KITTITAS COUNTY

MEMORANDUM

TO: All Staff
FROM: Public Works Plan Review Team
DATE: May 29, 2024, survey update December 9, 2024
SUBJECT: BL-24-00007 Gibson-Scott

RECORD OF SURVEY
A PORTION OF THE N 1/2 OF THE NE 1/4 OF SECTION 26,
TOWNSHIP 18 NORTH, RANGE 17 EAST, W.M.,
KITITAS COUNTY, WASHINGTON

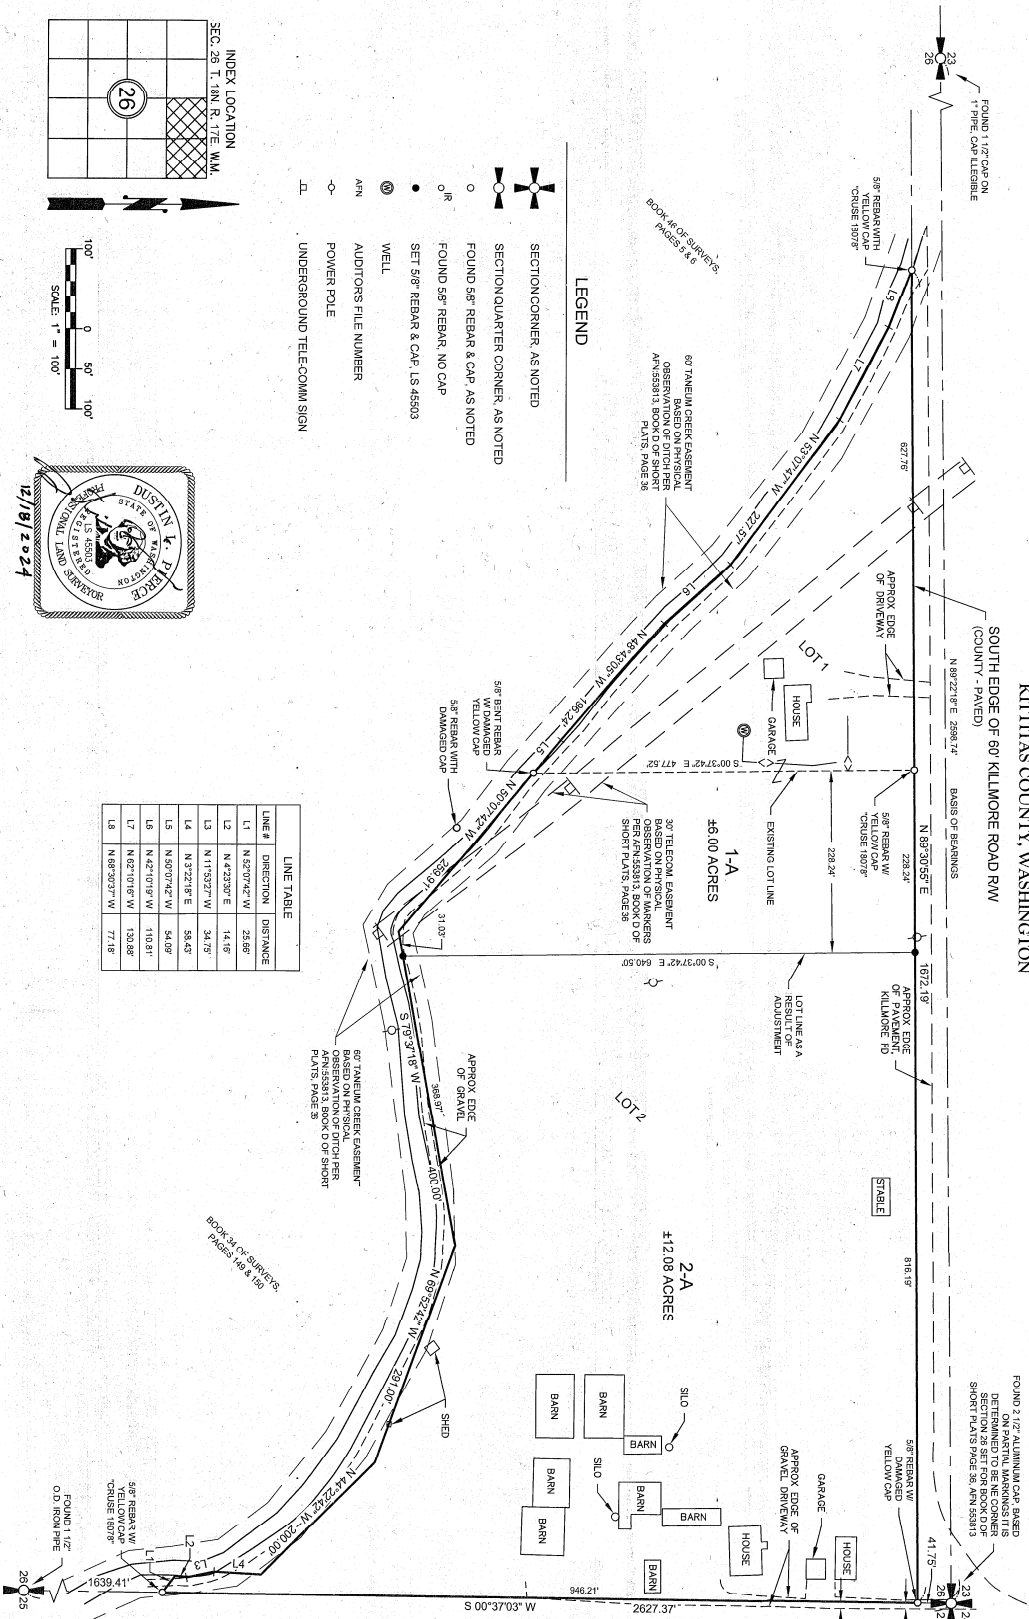
SURVEY	<p>The following map elements will need to be addressed prior to final:</p> <ol style="list-style-type: none">1. Identify Kilmore Rd with ownership (county), surfacing and total R/W width.2. Show distances to the usage limits / encroachments along the East boundary of Lot 2 A. <p>OF NOTE Lot closures were not provided or reviewed as part of this application. Given the simplistic nature of the BLA, these are not required. (JT)</p> <p>UPDATE 12/09/2024 All previous comments have been addressed as part of the revised map. (JT)</p>
